Part 5 of the Town & Country Planning (Development Management Procedure) Order 2015
Approval of details reserved by condition imposed under ref. BE/135/18/PL relating to
Condition No. 12 (full permission) regarding details of the proposed surface water drainage
scheme for the Salt Box site.

Land at Salt Box, West of Shripney Road, Bognor Regis

Arun District Council have decided to **REFUSE details reserved by this condition**

Title: UNITS 4, 5 AND 8 DRAINAGE LAYOUT

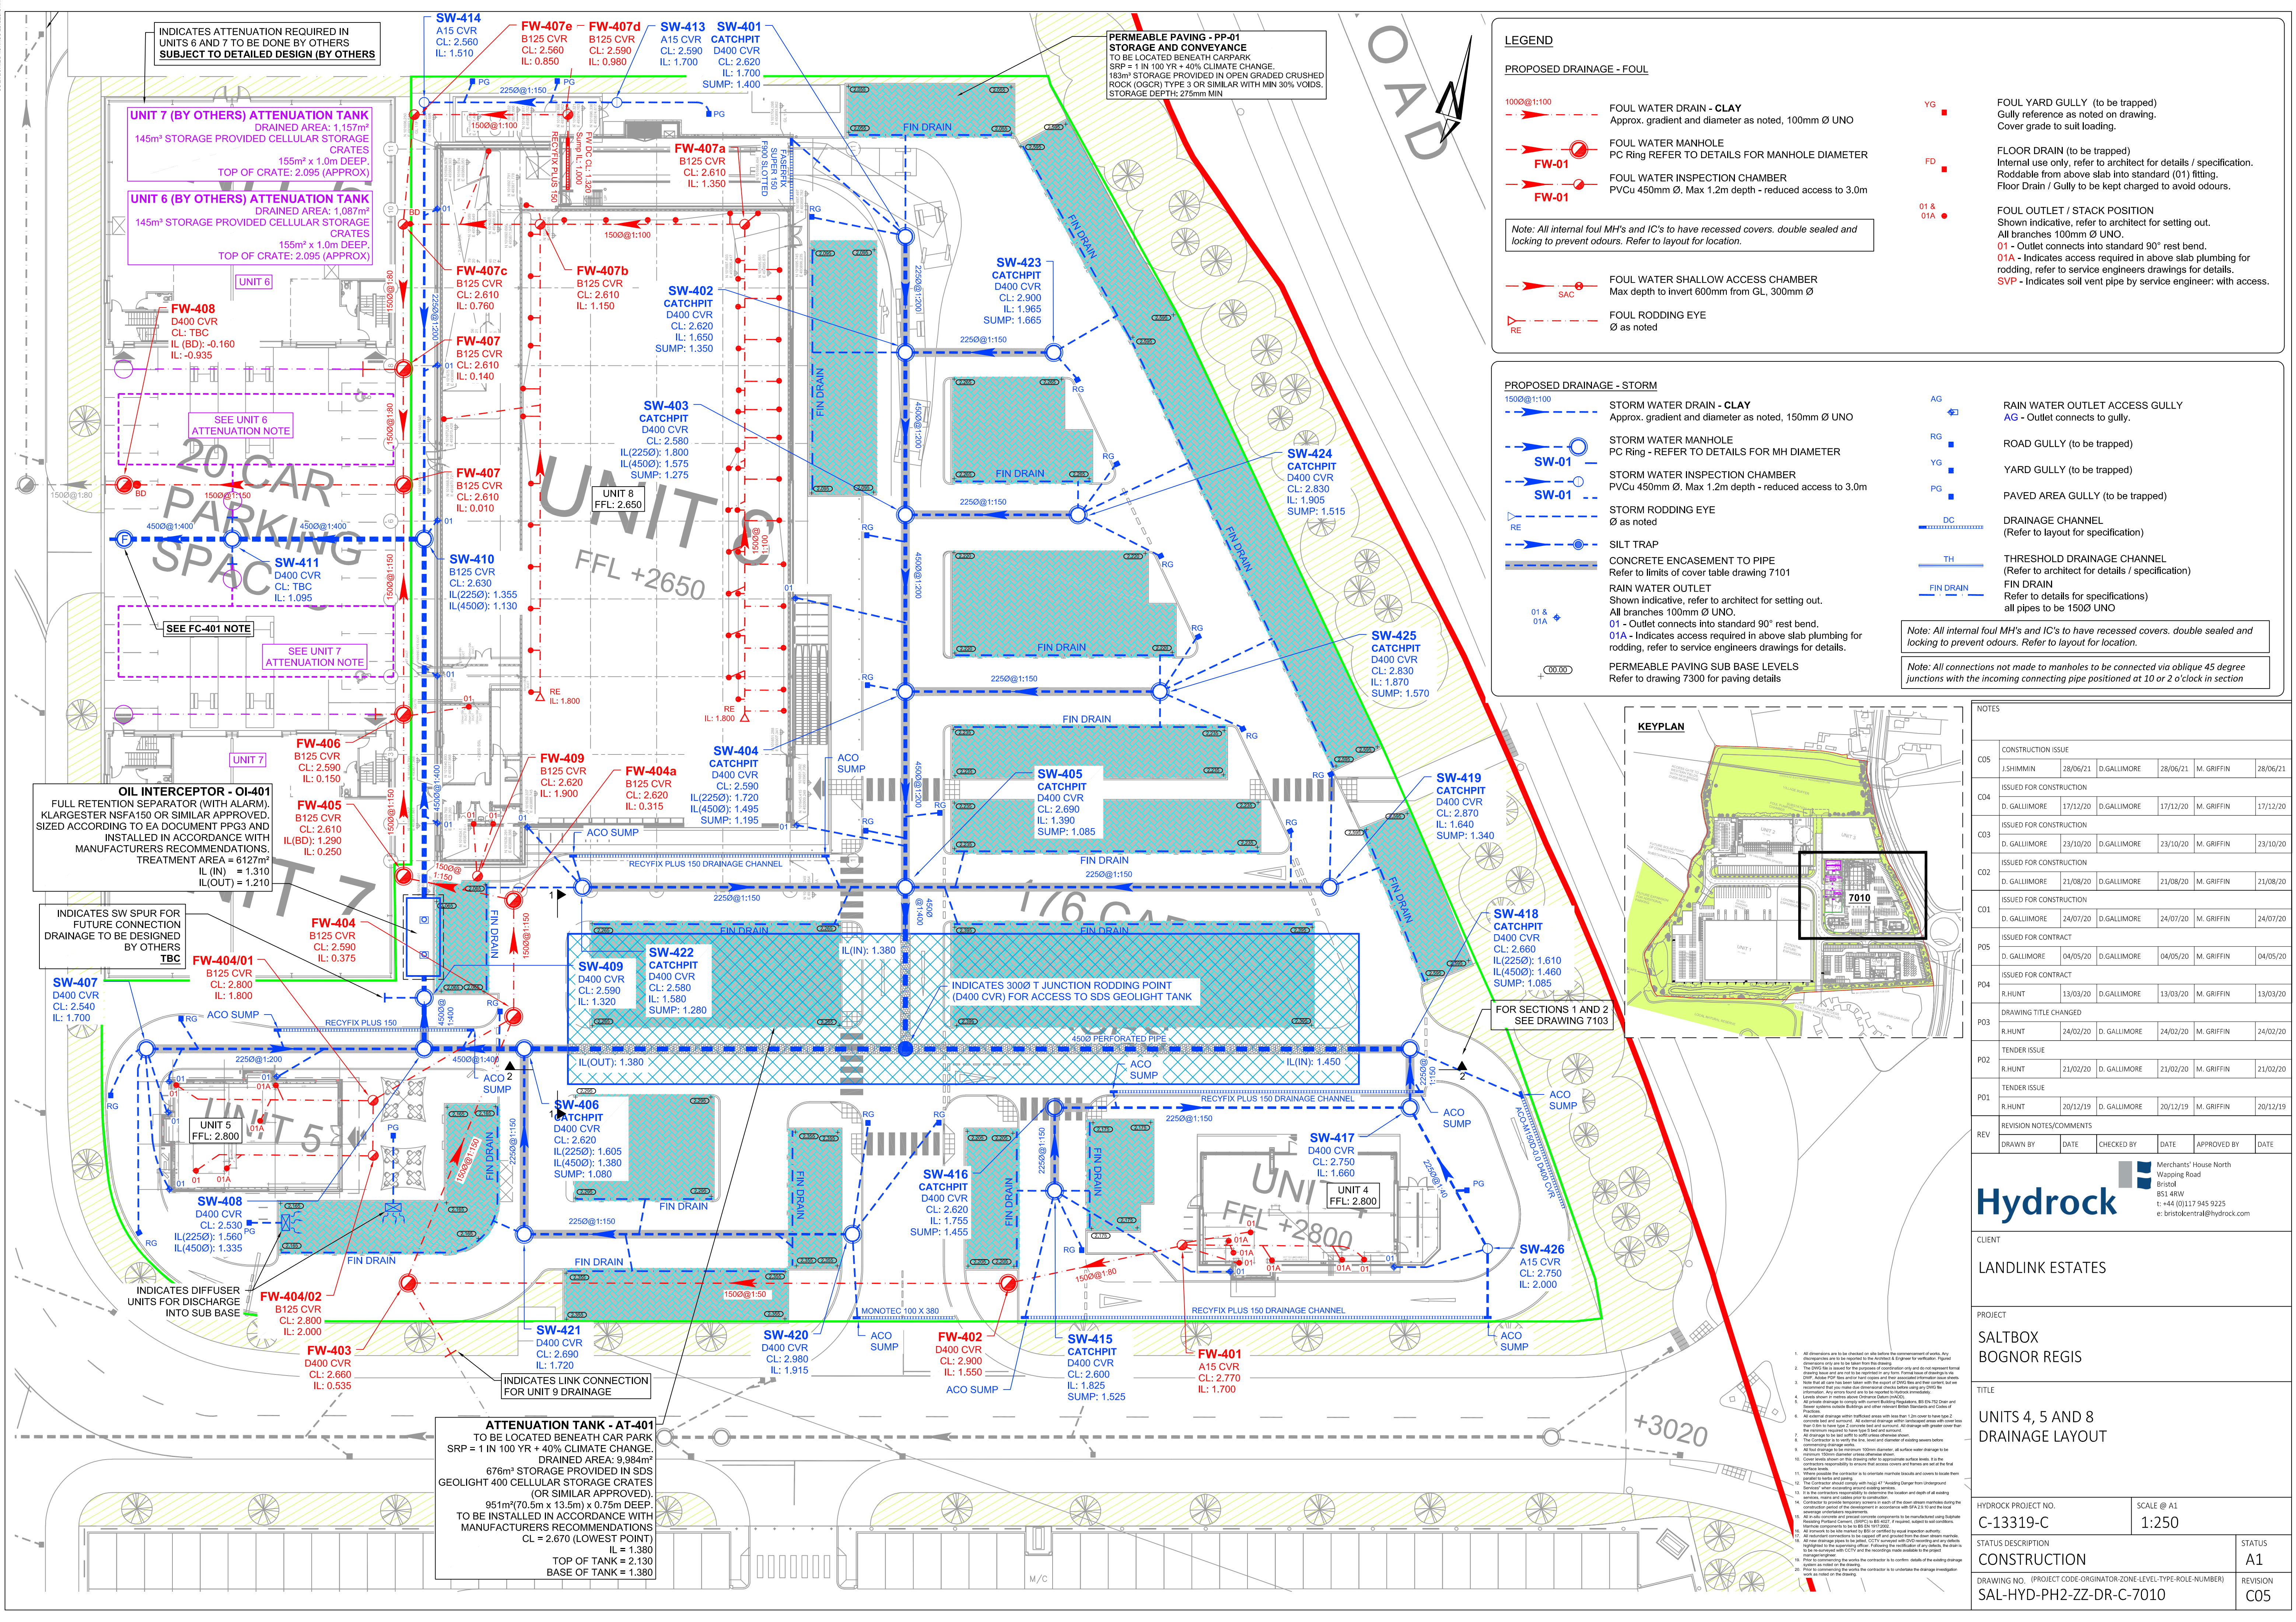
It is evident that substantial changes have been made to the drainage since the approval. A review of these changes has been completed. Levels at some manholes are considerably different between the approved design and as built drawings, the difference in levels is in excess of 50mm in some areas. It appears that at one location an outgoing invert is significantly above the incoming invert to the chamber, and in others downstream inverts are higher than the invert levels of upstream attenuation crates.

Due to the number of discrepancies and the potential significance of these the surface water drainage network would need to be remodelled and updated calculations would need to be provided to demonstrate whether the drainage as constructed meets policy requirements.

Pipe diameters and slopes have not been confirmed. If the fall of a pipe is different over its length, but the distance is the same, the slope of the pipe simply cannot be the same. Gully locations and levels have changed from those designed, gully cover levels have not been labelled on drainage plans.

The type of channel drains constructed are different to that approved. Details of the exact channel drains constructed have not been supplied to evidence that these are suitable for the loading conditions and are appropriately sized to drain their catchment areas.

TITLE
UNIT 2 DRAINAGE LAYOUT SHEET 2

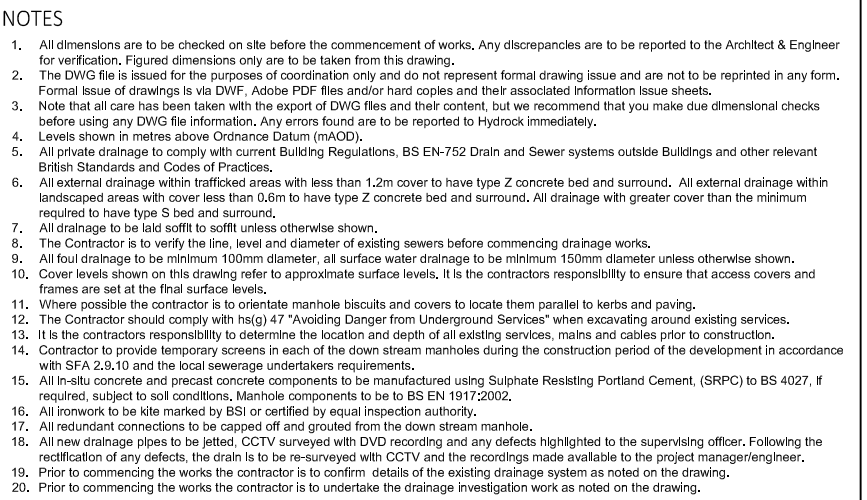
The headwall angles have been altered since approval. No evidence has been submitted to prove that the relevant consents (FRAP and Land Drainage Consent) apply to the revised headwalls.

The information presented is insufficient to evidence that the as-built drainage meets policy requirements, contrary to Policy W DM2 and Policy W DM3 of the Arun Local Plan and the National Planning Policy Framework.
